**Planning Department
Transportation Development Services Section**

**Re: Certification Submittal for Certificate of Occupancy for
Uptown Dental Associates, 7101 Prospect Pl. NE
Architect's Stamp dated 2-24-14 (H19-D081)**

The Letter of Certification submitted on 2-24-14 is not sufficient for acceptance by this office for final Certificate of Occupancy (C.O.). The following items need to be addressed:

AS-101-AA

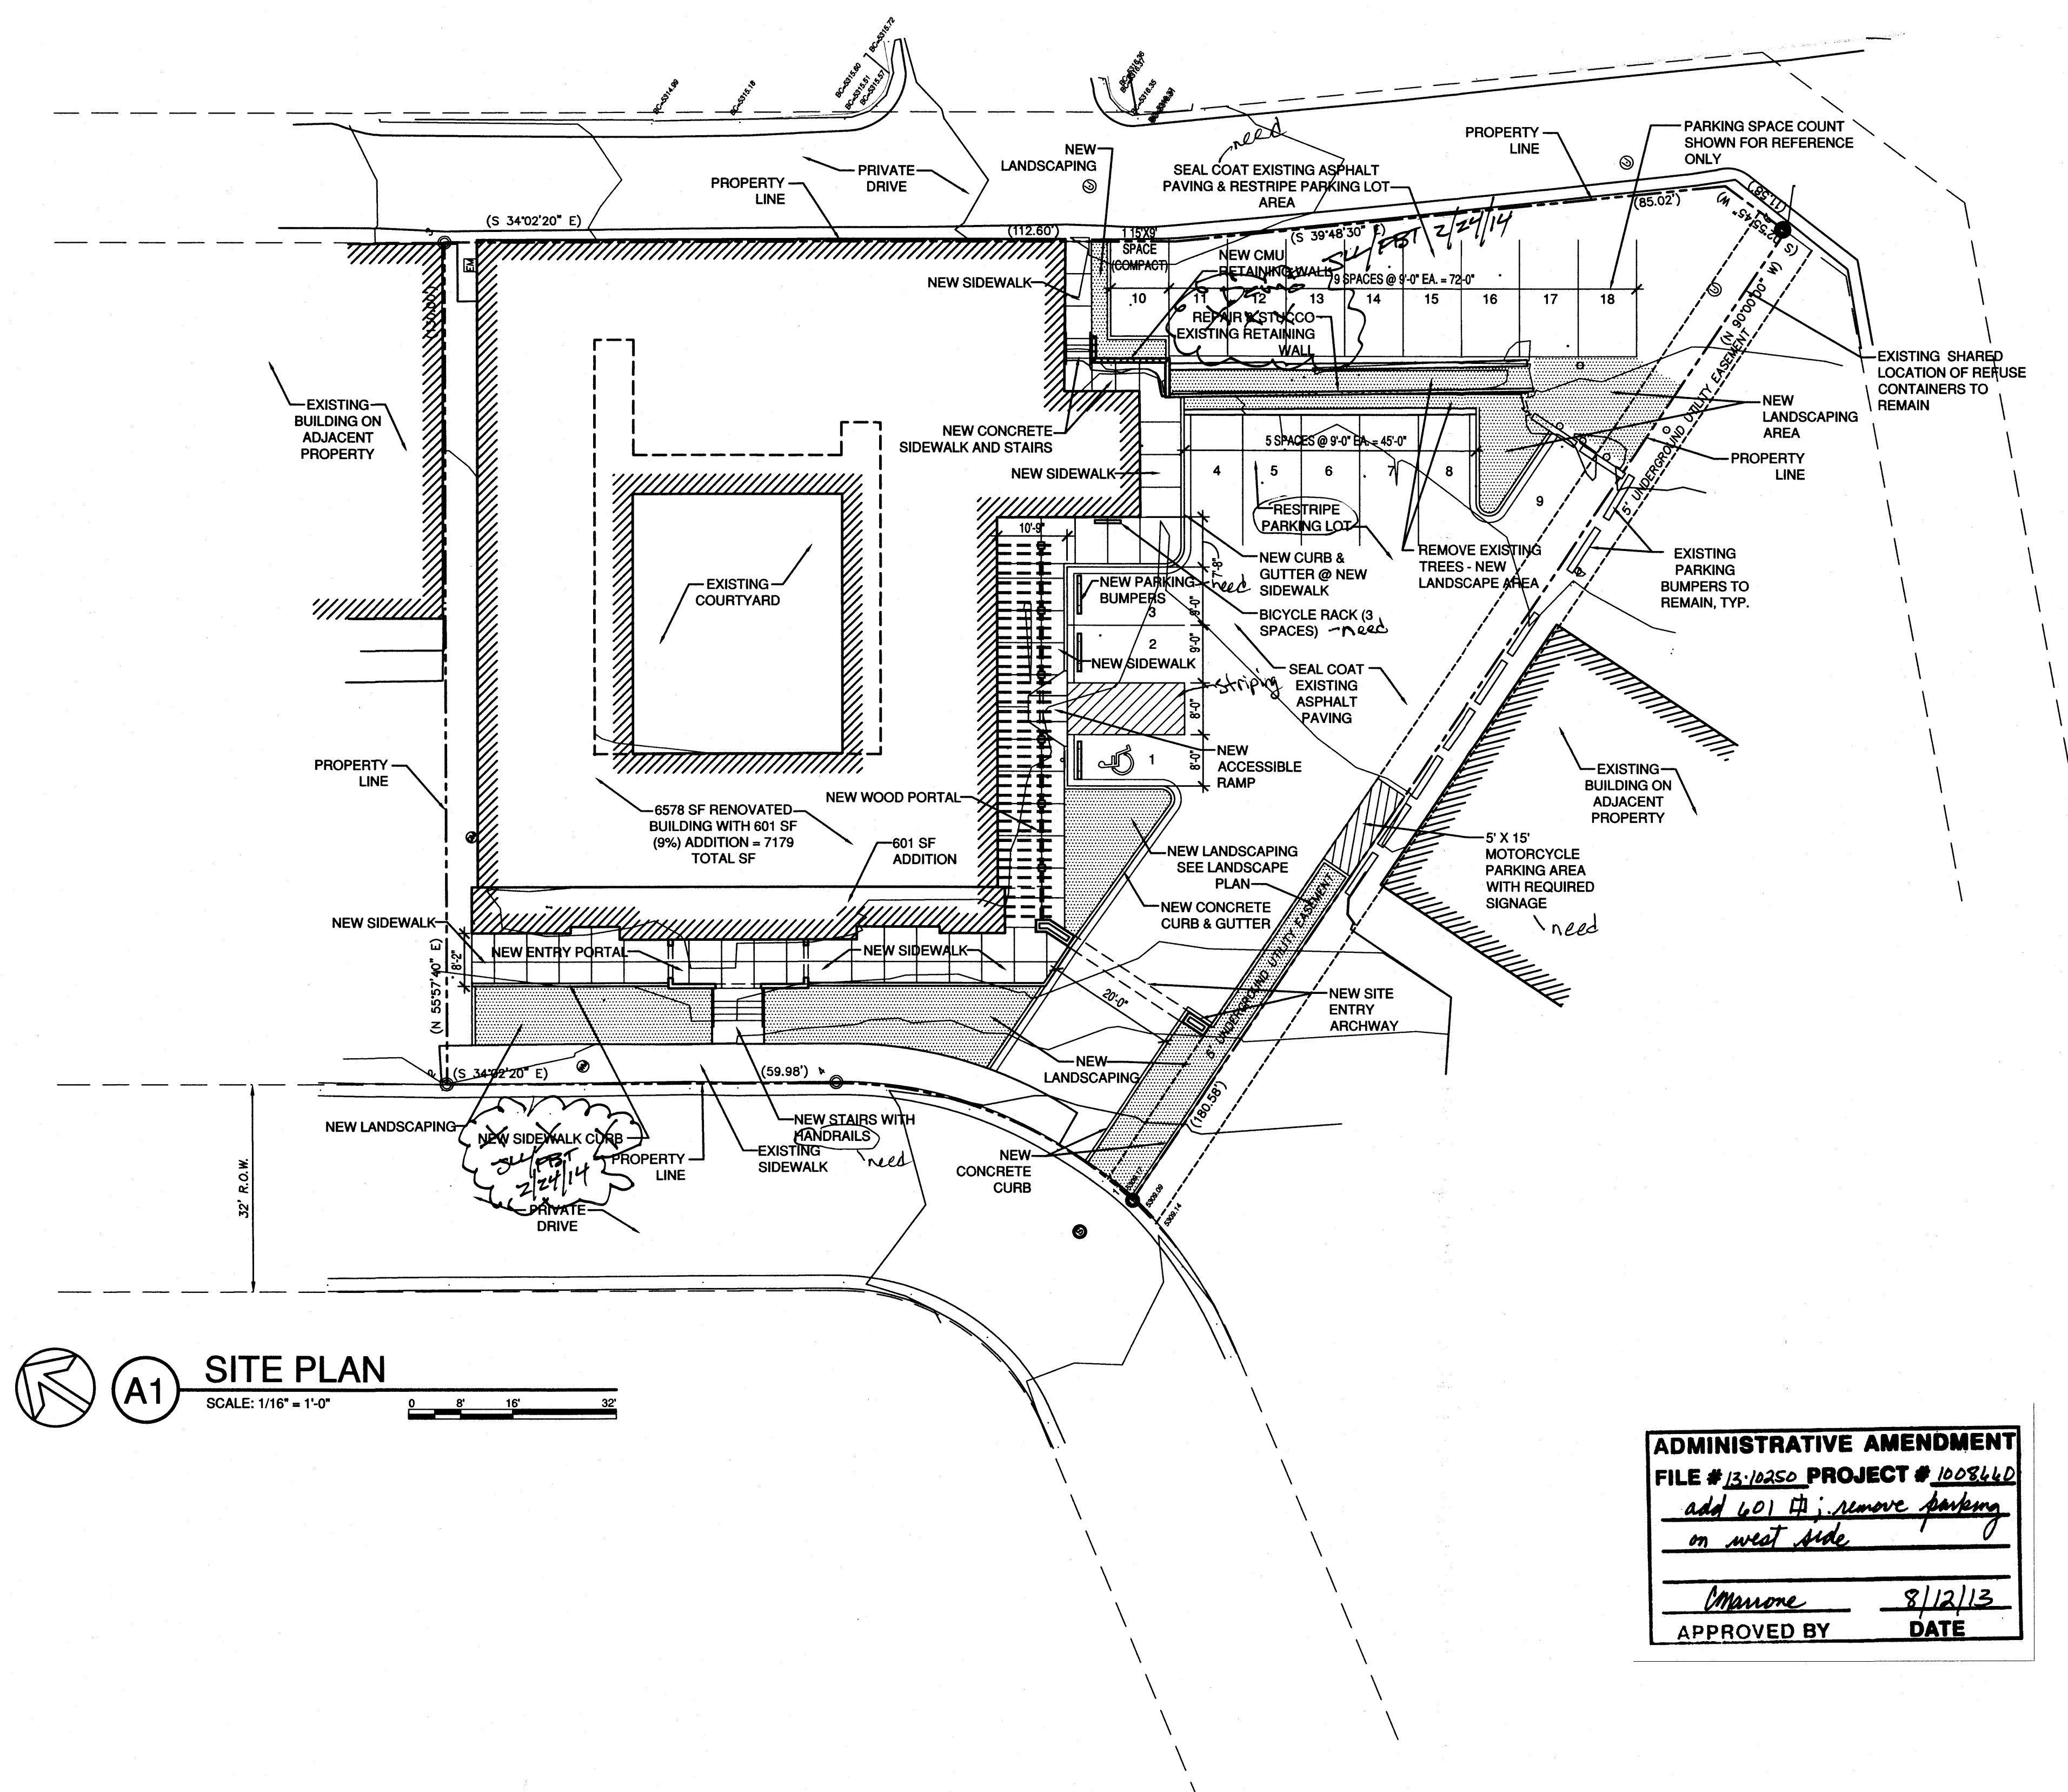
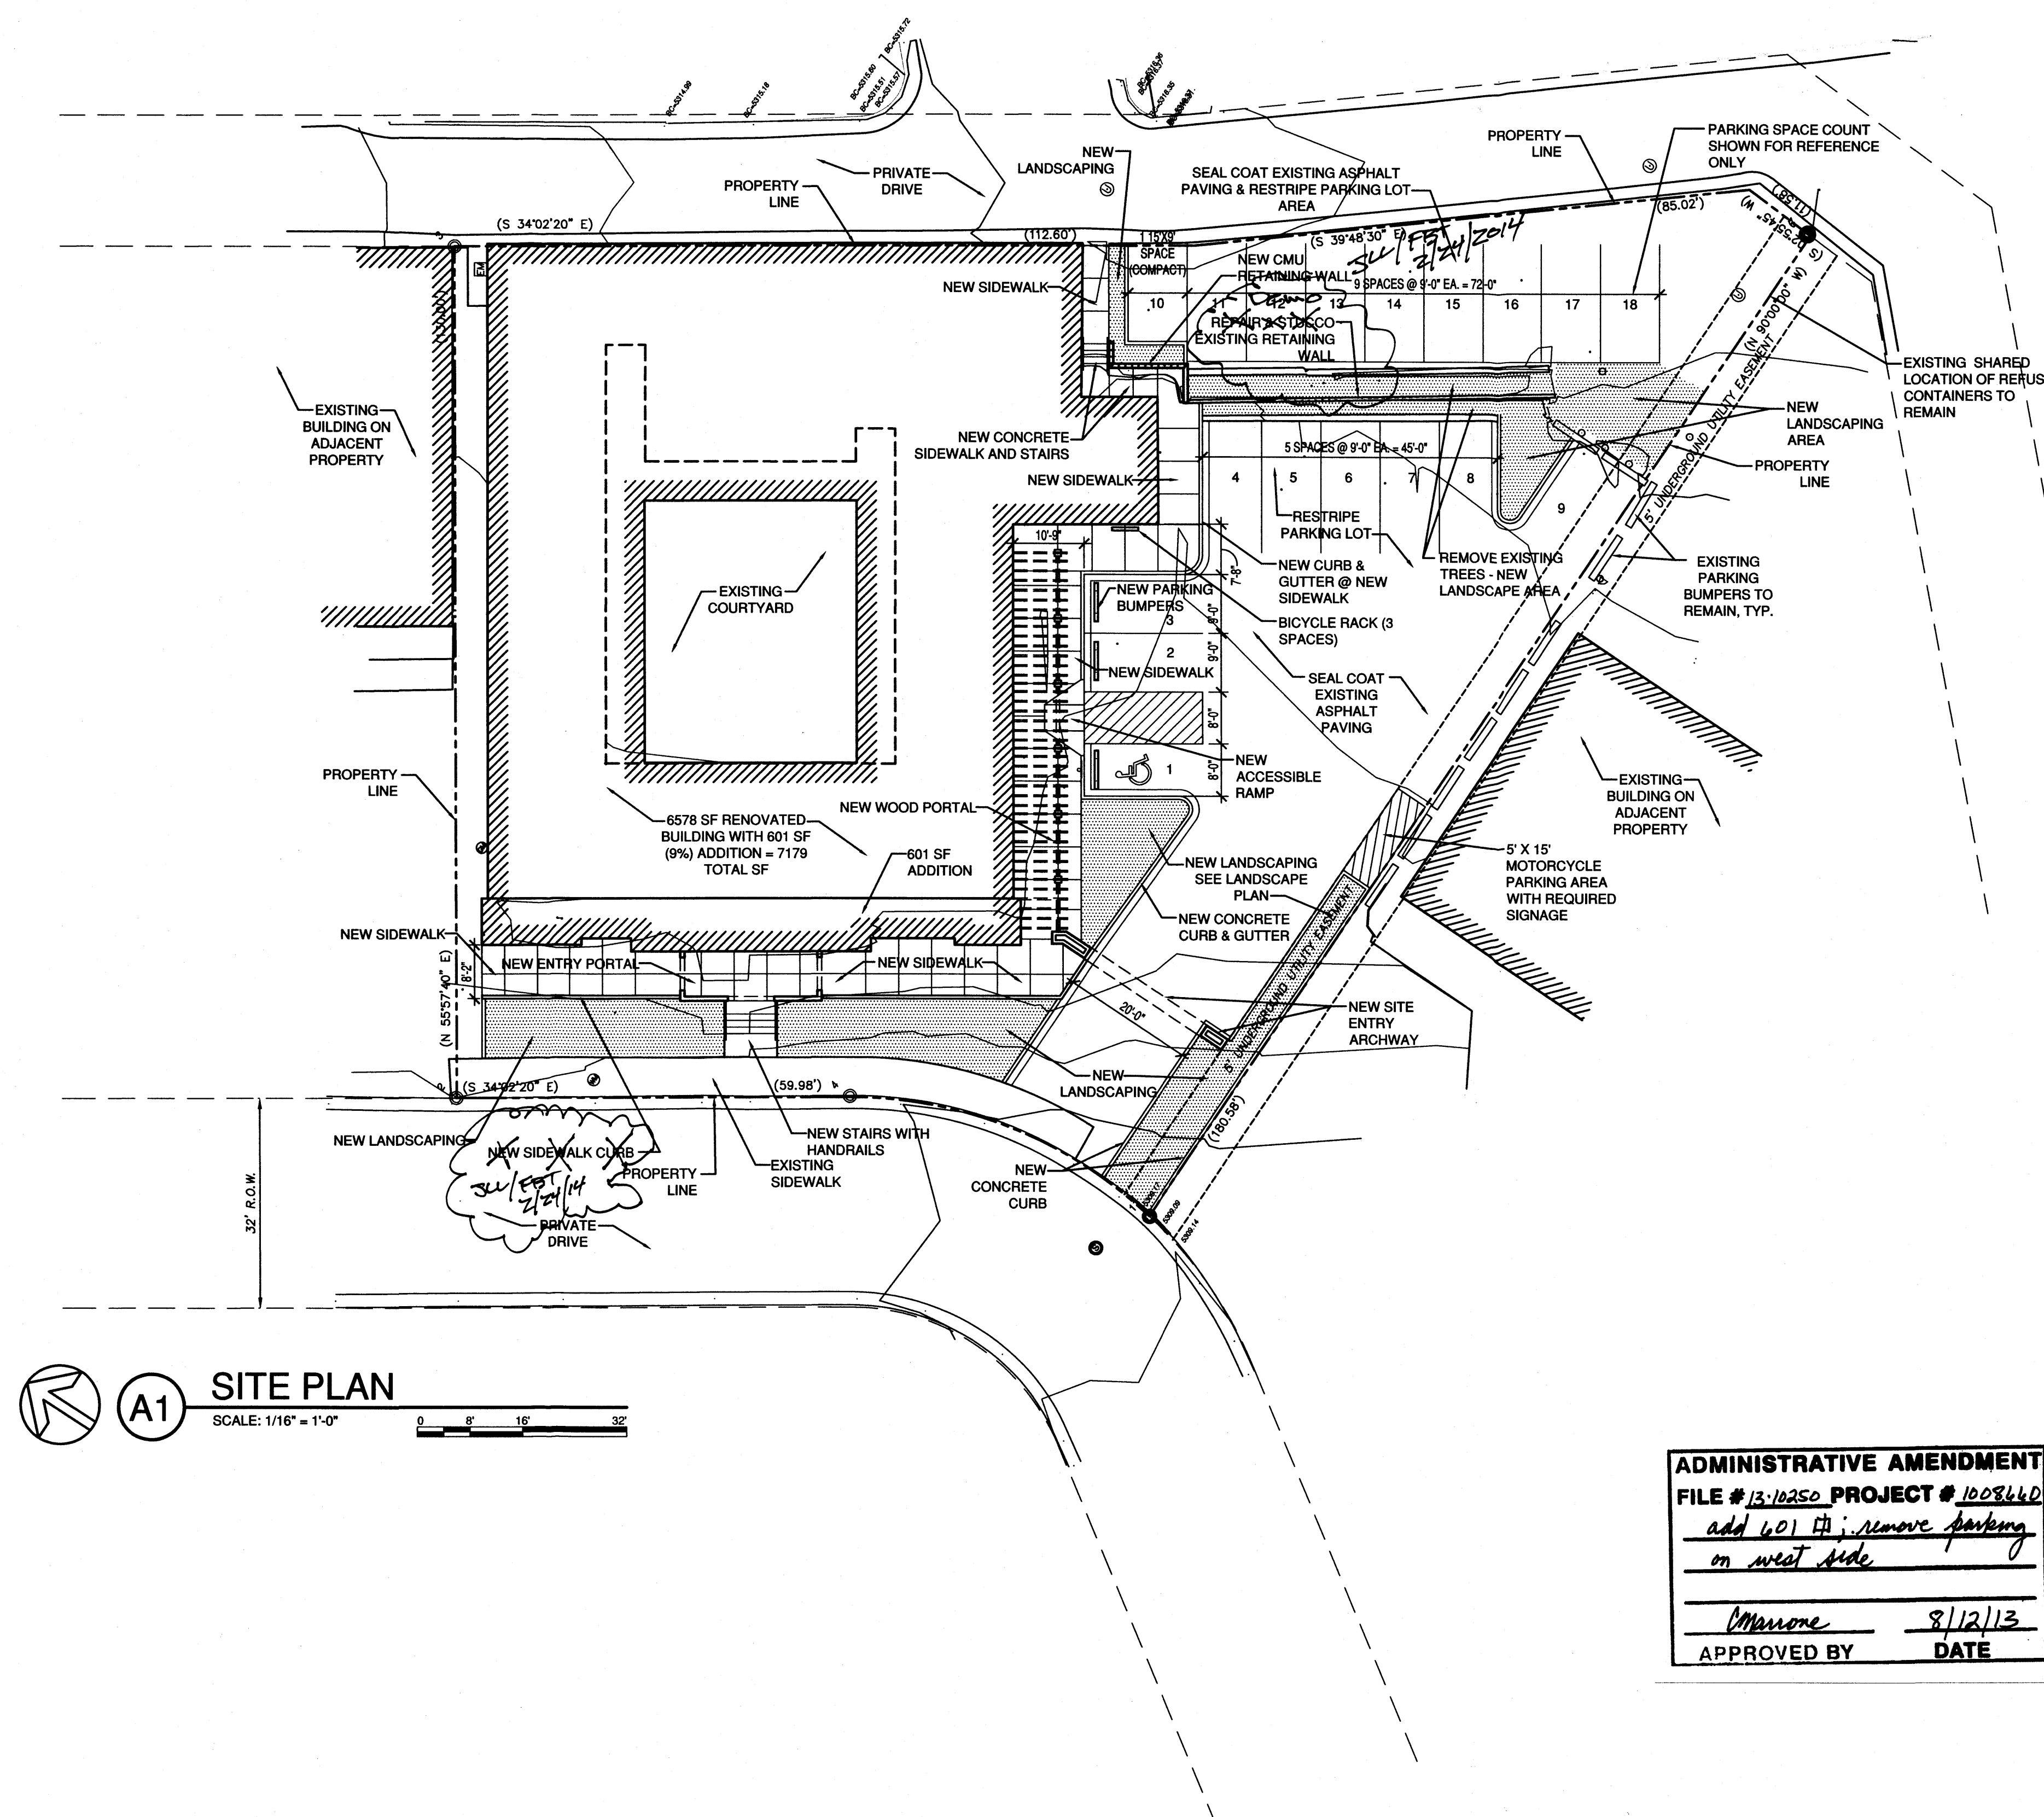
| Albuquerque | • All areas indicated on the plan as being restriped still need to be striped. |
| | • Sidewalk at front of building needs to be finished, specifically the connection to the adjacent property at the north. |
| | • Handrails need to be installed at the new stairs in the front of building. |
| | • Parking bumpers need to be installed where indicated on the plan. |
| New Mexico 87103 | • All handicap accessible parking signage and striping needs to be installed. |
| | • Bicycle Rack needs to be installed. |
| | • Motorcycle parking area striping and signage needs to be installed. |
| www.cabq.gov | • Sealcoat paving needs to be installed where indicated on the plan. |
| | • Sidewalk culvert covers need to be installed at gutter locations. |
